To: Highways England, A303Stonehenge@highwaysengland.co.uk

A303 Stonehenge - Amesbury to Berwick Down - Public Consultation

Drawing file: TR010025 / TR010025-001755-Figure 13.3A and B Proposed Public Rights of Way Revision 3.pdf

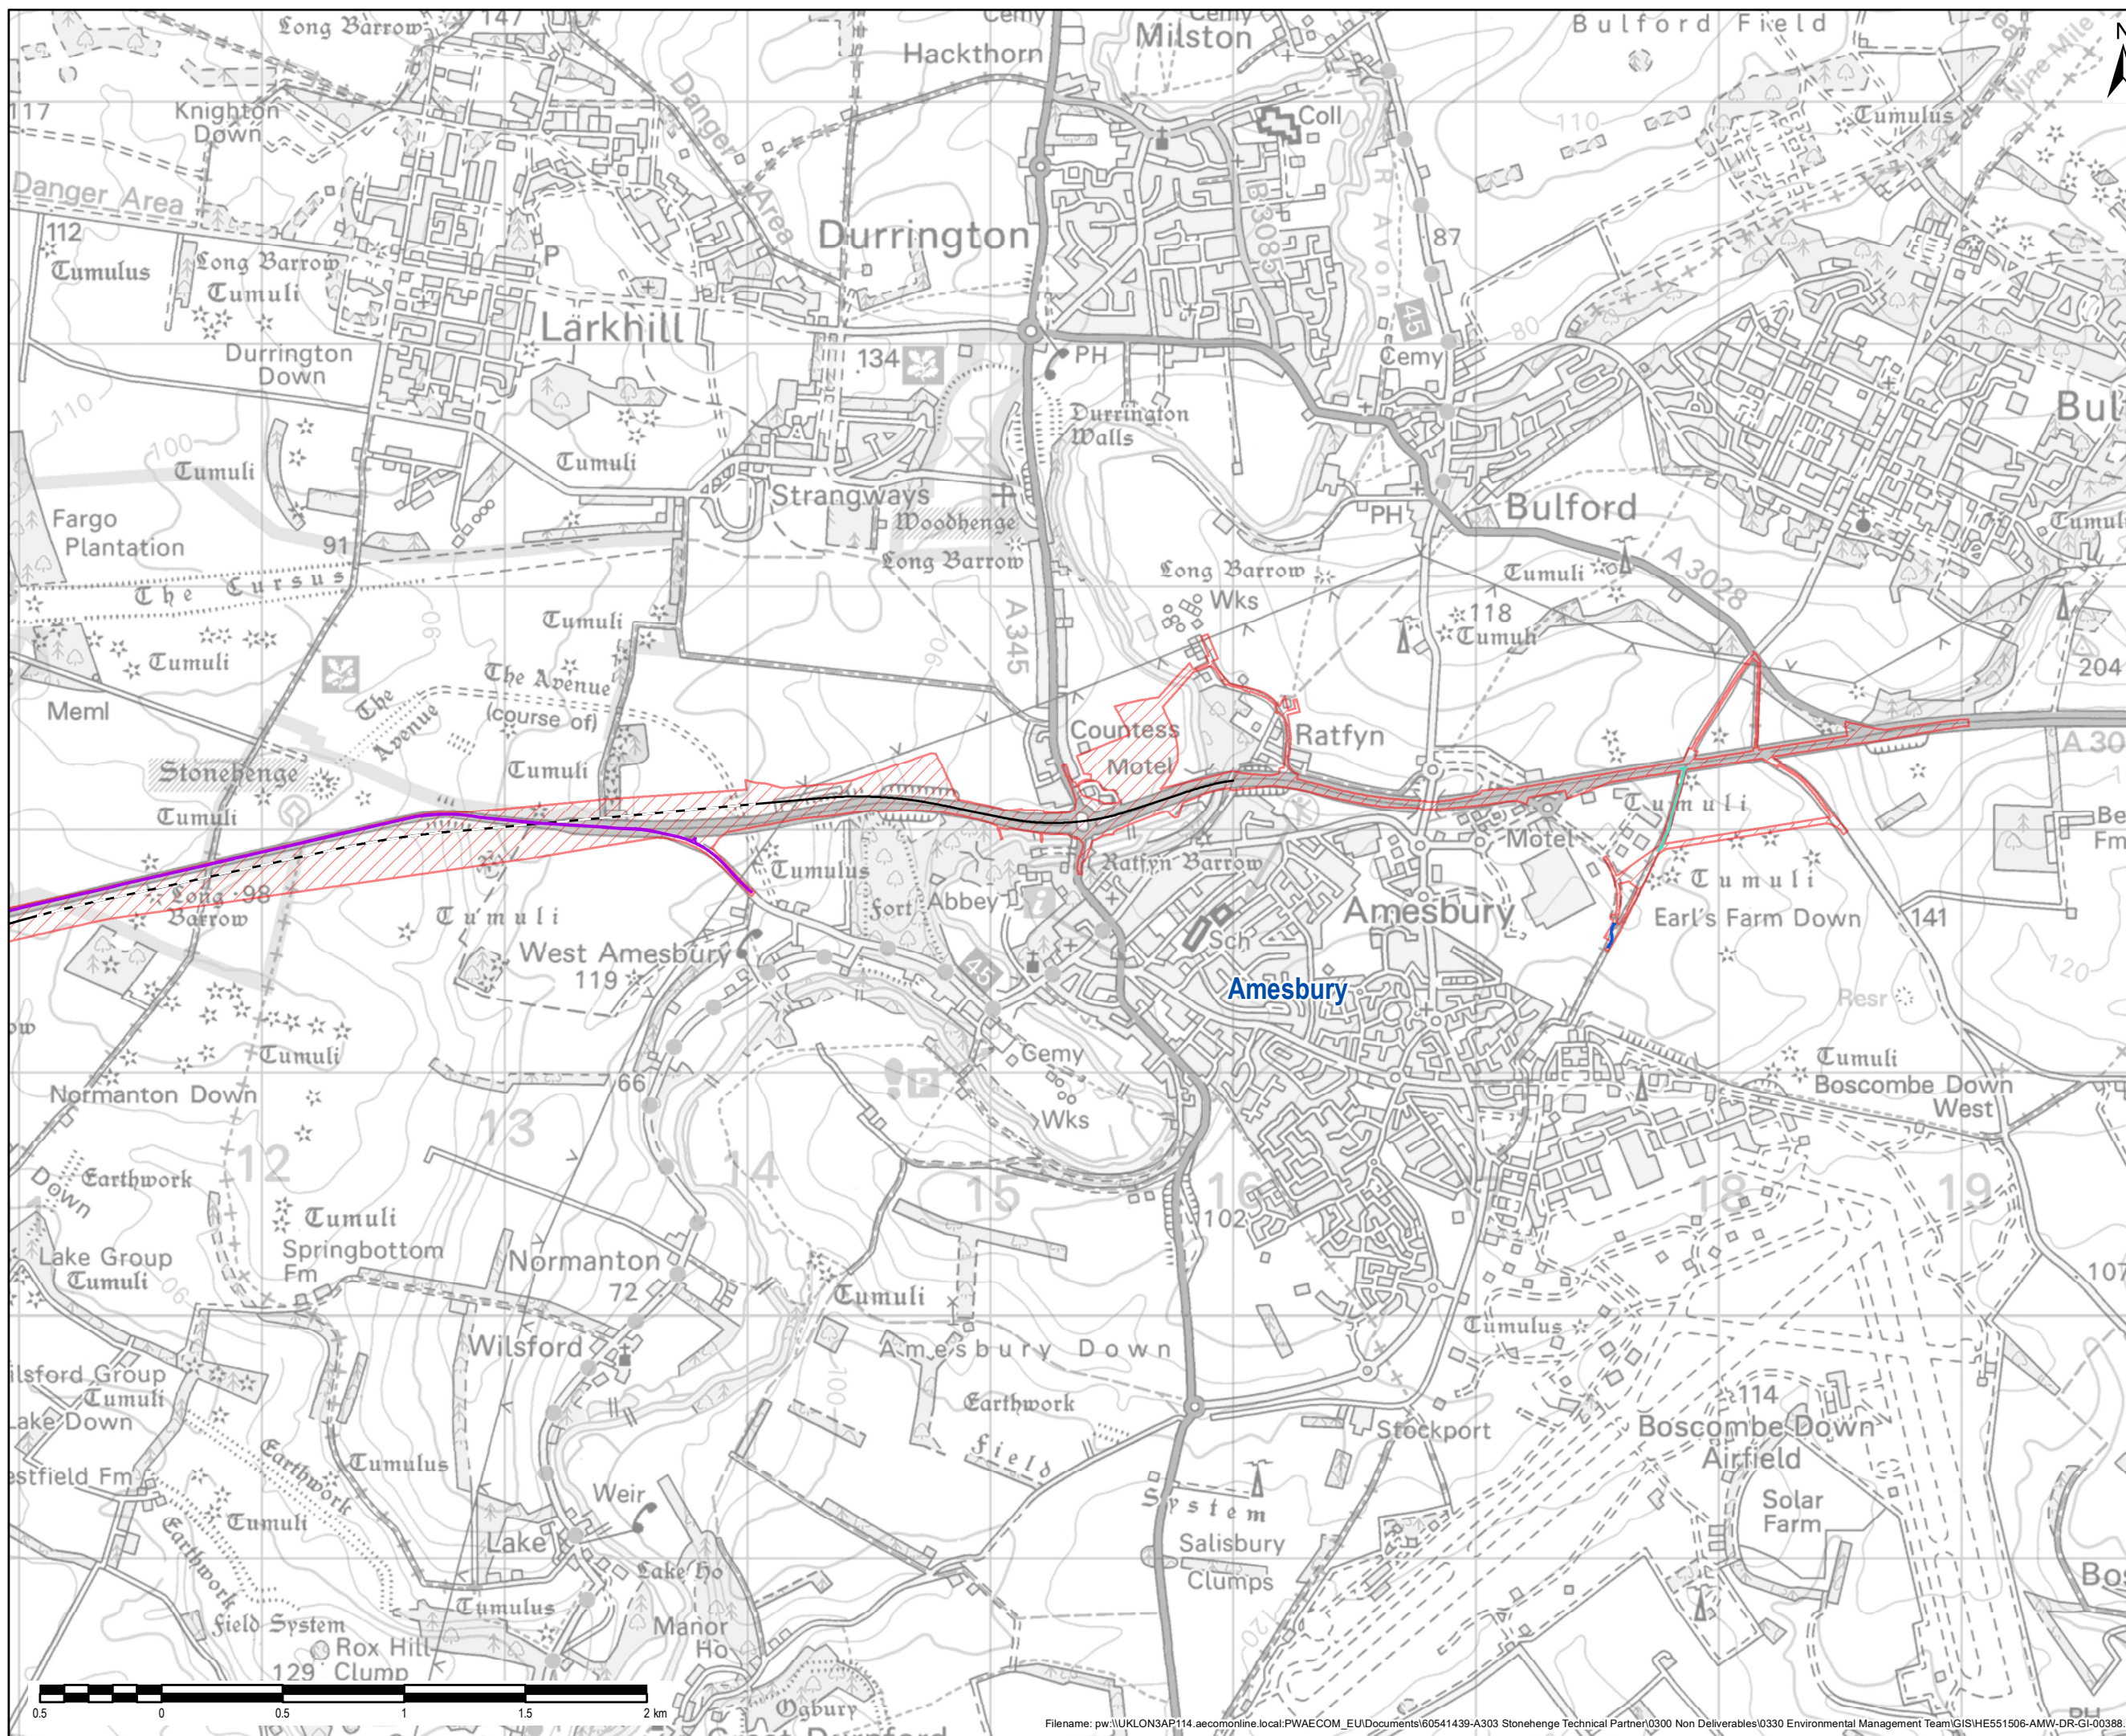
However, although the published scheme has the potential to return full access for vulnerable road and rights of way users, both to and through the World Heritage Site (WHS), as yet it lacks sufficient detail to give full support. In particular the existing and proposed new routes:

- along the existing A303 alignment from Stonehenge Road to Longbarrow,
- along the A360 alignment at Longbarrow and linking towards Winterborne Stoke, and
- the new link from Solstice Park, Amesbury to the Allington Road,

must all be of sufficient quality to enable full 24/7/365 safe easy use by any form of cycle.

Specifically, for the A303 route from Stonehenge Road to Longbarrow it is requested that at least a 4m width of the existing road is retained throughout this length, with a new surface layer of green tarmac (as used for bus lanes in some UK cities) overlaid, so that this enhanced high quality surface blends into the surrounding grassland.
